20. COPE VIEW
EAST PRESTON
WEST SUSSEX
BN16 1AY

RE EP/48/18/POH.

REASONS FOR OPPOSING THIS PROJECT

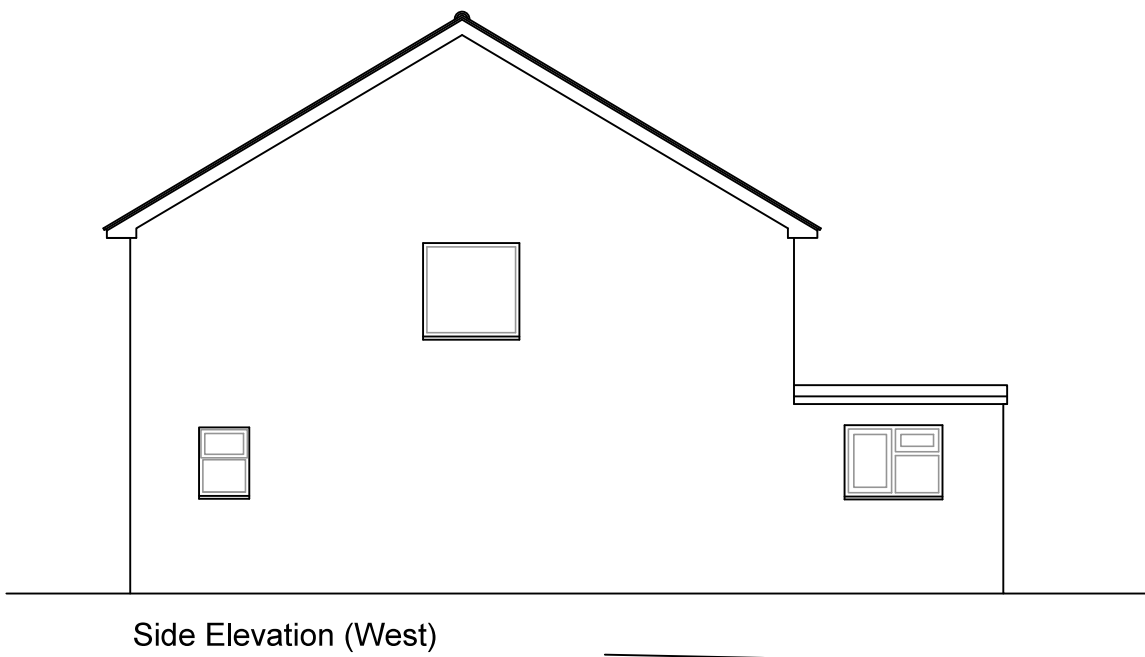
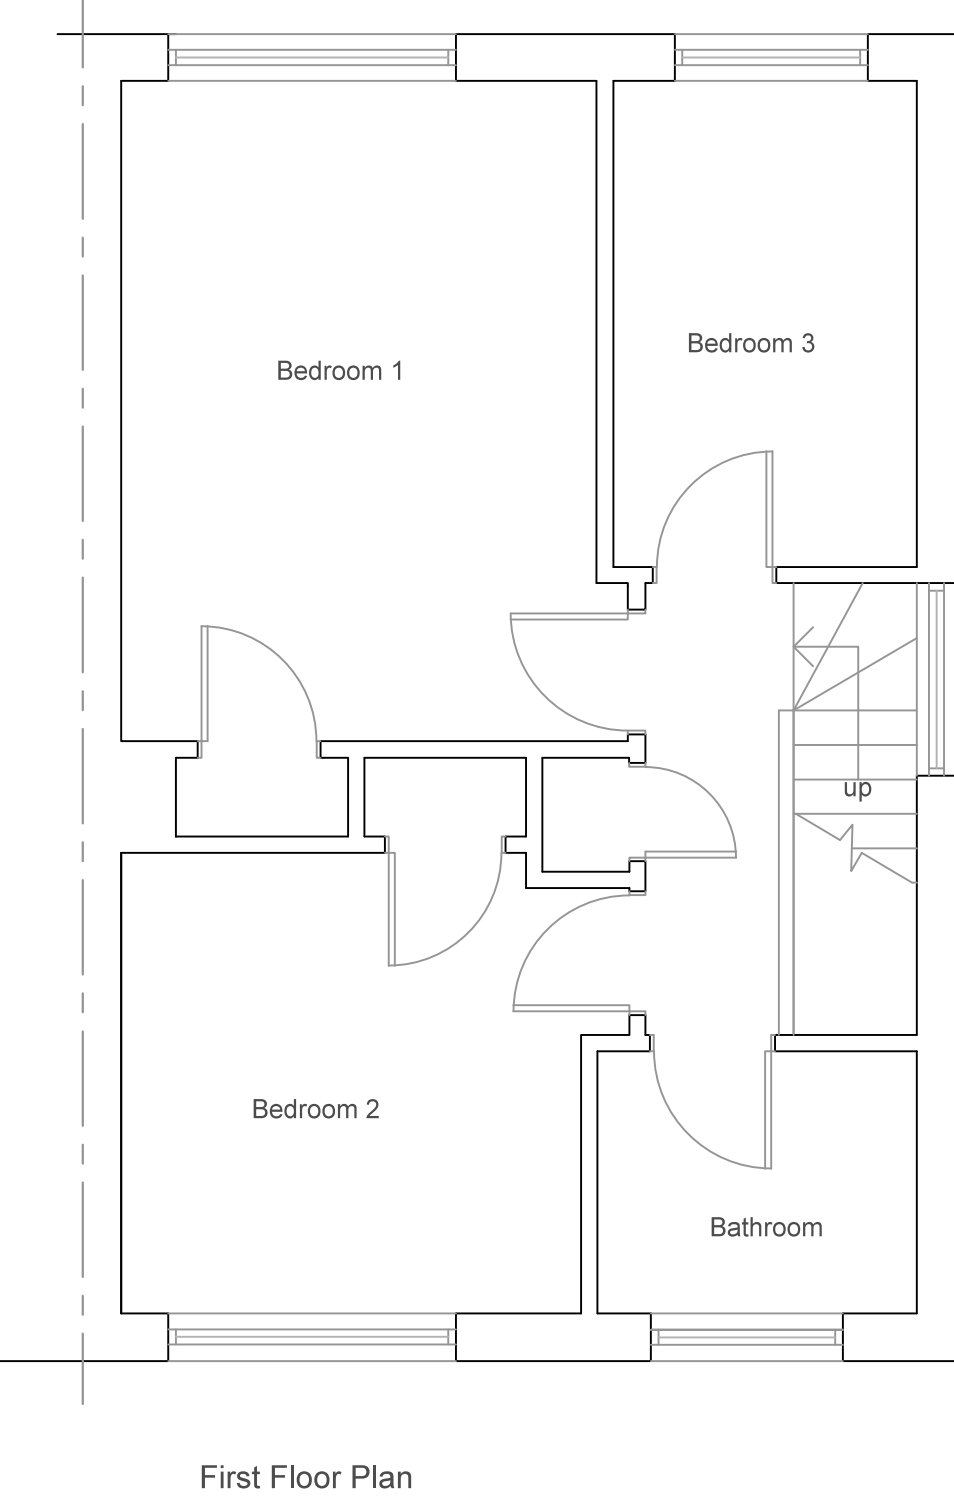
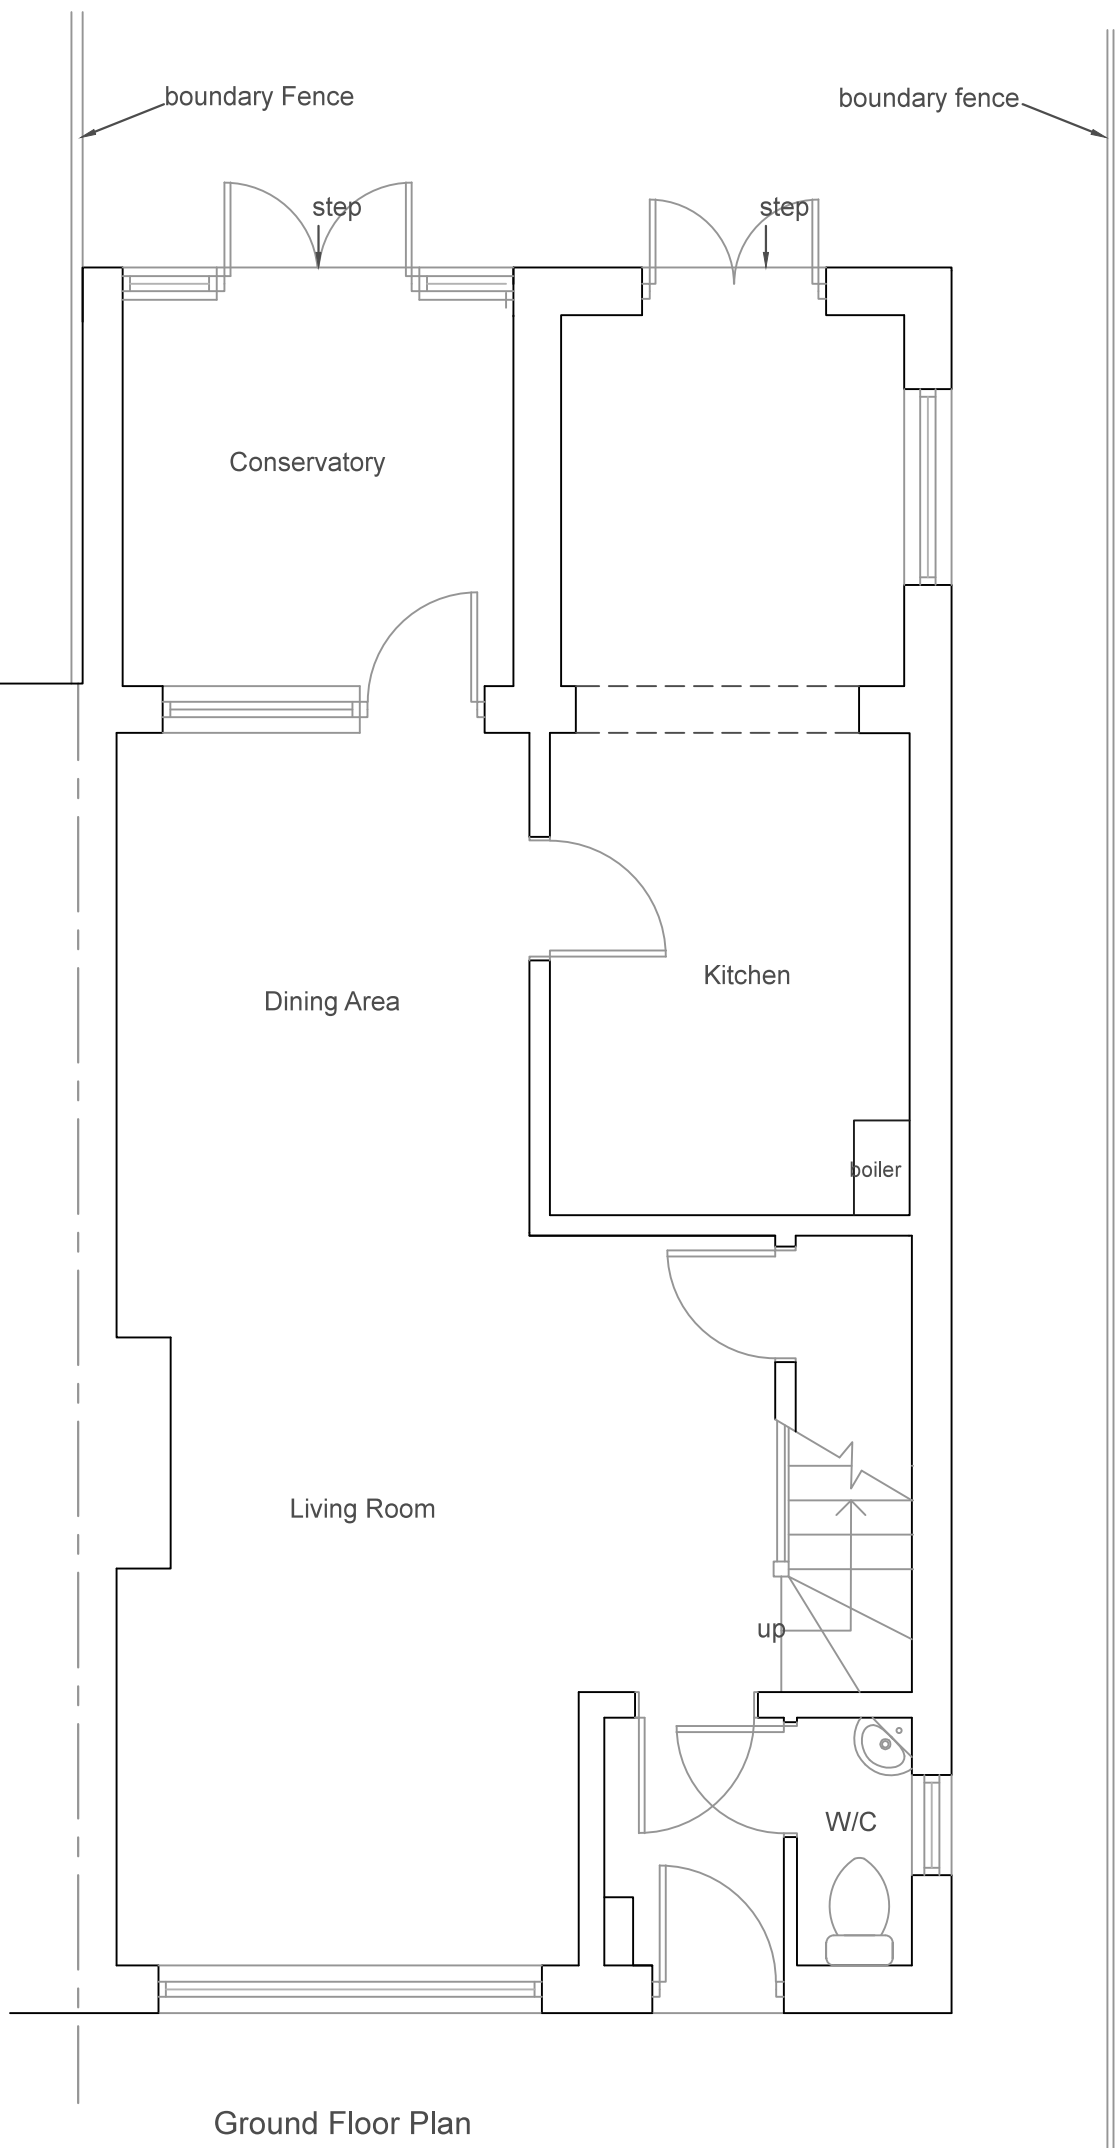
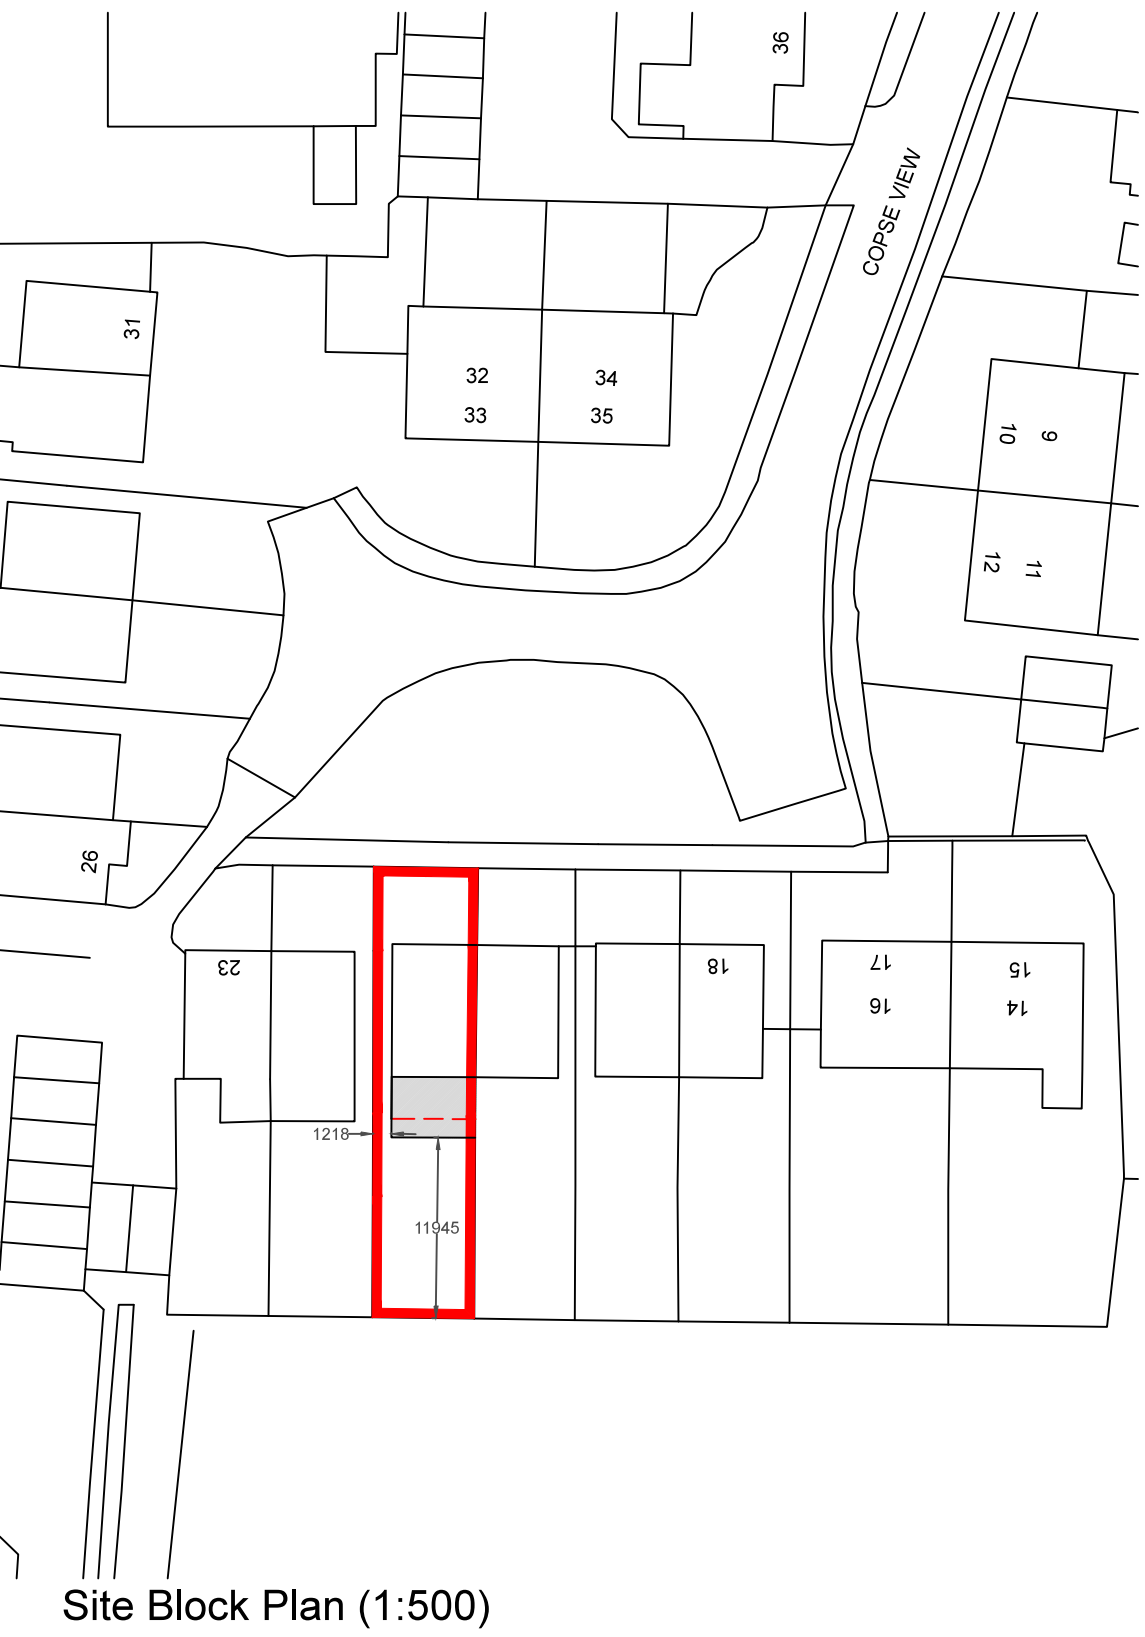
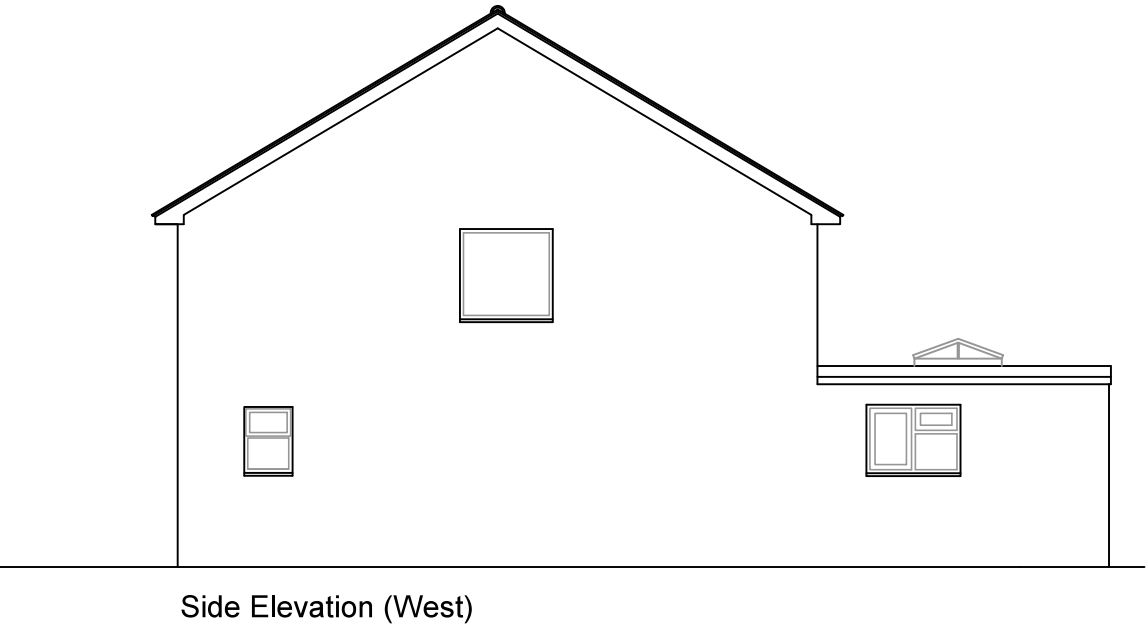
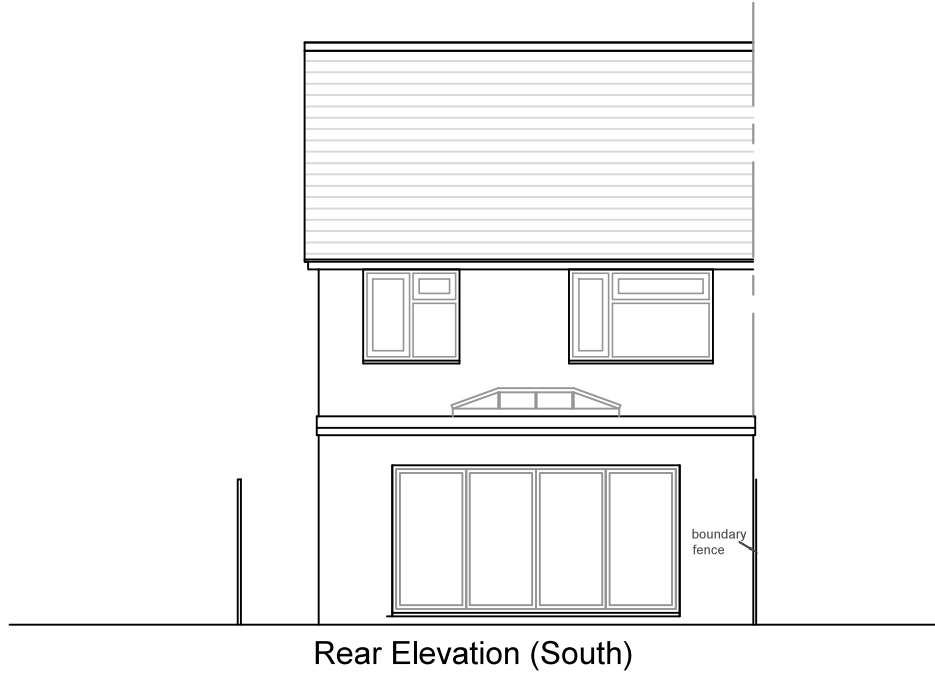
If this application is granted, it Looks from the Plans that he wants to Build about another 14" higher possibly to put windows above the fence Height so he can open the window. Well as the Situation is it could effect the sale and price of our House. the new build if granted needs to have a new wall built further into his garden so he can maintain the Wall and any window he might have from his own Land. I wonder what would happen if I were to take the fence down on the party wall line and built up a solid wall pass his windows I would like to get this problem resolved. because if I did want to sell, and managed to sell we would only be passing the problem on, and that cant be right.

- 1 BECAUSE THE WALL NEEDS TO BE MOVED OVER INTO HIS GARDEN SO IT CAN BE MAINTAINED PROPERLY FROM HIS OWN LAND AND NOT PUT OTHER PEOPLE OUT EXAMPLE CLEANING WINDOW AS ON THIS EXISTING BUILD.
- 2 AS THIS ABOVE SITUATION EXIST IT COULD DEVALUE OUR PROPERTY AND MAKE IT HARDER TO SELL.
- 3 THE EXTENSION WILL BE THE LARGEST BUILD ALONG OUR STRIP OF BACK GARDENS THE GARDENS ARE ONLY 51ft LONG AND 21ft WIDE SO OUT OF PROPORTION.
- 4 I WOULD BE THE ONLY HOUSE EFFECTED BY THIS PROPOSED BUILDING IT WOULD PROJECT 4m FROM THE ORIGINAL REAR WALL AND TOWER ANOTHER 14" HIGHER.
- 5 THE SIZES OF THE NEW BUILD WOULD CUT OUT A LOT MORE LIGHT FROM OUR DINING ROOM TUCKED UP BEHIND THIS EXTENSION. NOT TO MENTION THE AIRSPACE.

6 By the time this proposed extension is erected 4m from the rear original wall and the folding doors are left open. Plus the garden furniture & parasols plus the garden shrubs the other side of my fence in his garden there won't be much airspace in the I have kept a low fence for these reasons

THE PROJECT WILL HAVE A FLAT ROOF

WILL IT BEABLE TO SUPPORT A LADDER.
